File Ref: SSD-10468

Inner West Council response: SSD-10468 – Warehouse and Customer Fulfilment Centre, Marrickville

Property: 74 Edinburgh Road, Marrickville

OVERALL STORMWATER PLAN GROUND LEVEL	
DATE:	AUGUST 2020
SCALE:	1:500 @A1
Project No.	190372
DRG.No.	C01
REV-B

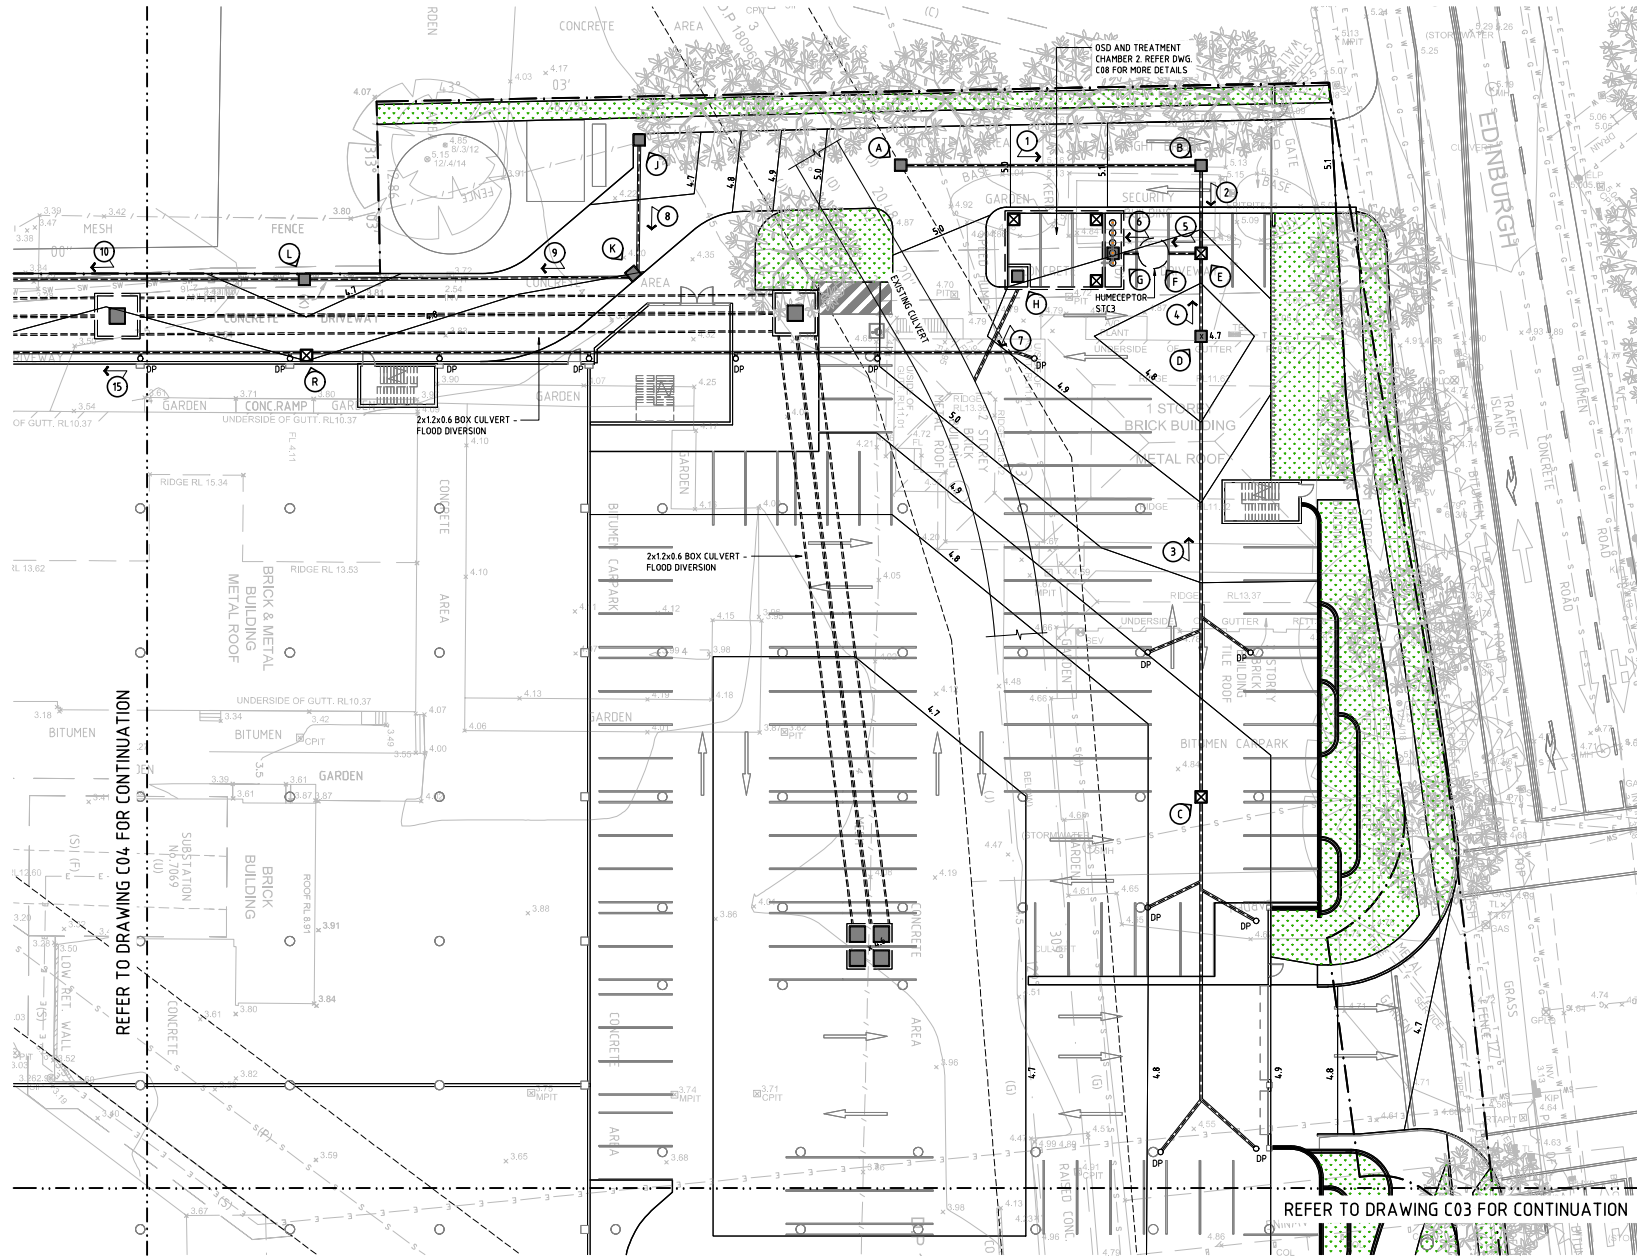
- ii. The improvement post development in flood depths is achieved by collecting the flood waters by large pit inlets and diverting them to an underground flood detention of 1200m³ volume equal to the existing site's above ground 1% AEP flood storage. No information has been provided on the design of these inlet structures or if any blockage factors have been applied to the modelling. It is Council's experience that "grate only" inlet structures block readily and do not achieve their design capacity. The inlet structures should incorporate kerb inlet, or "letter box" type inlet structures that are less prone to blockage with best practice blockage factors applied. Details of an overland flow path should also be provided in case of failure of the system.

- i. A Council Stormwater pipe drains through the site to the existing Sydney Water Channel. This pipe has not been detailed on any of the submitted plans and it appears that it will be built over which is not acceptable and contrary to Councils DCP 2.25 (Control C31). Council's stormwater asset shall not be built out but be suitably relocated away from the proposed building;
- ii. Similarly, Sydney Water's stormwater infrastructure is also proposed to be built over, contrary to their guidelines. The stormwater plans even detail columns within the location of the stormwater channel. It is recommended that the applicant approach Sydney Water regarding their requirements with regard to the Stormwater Channel.
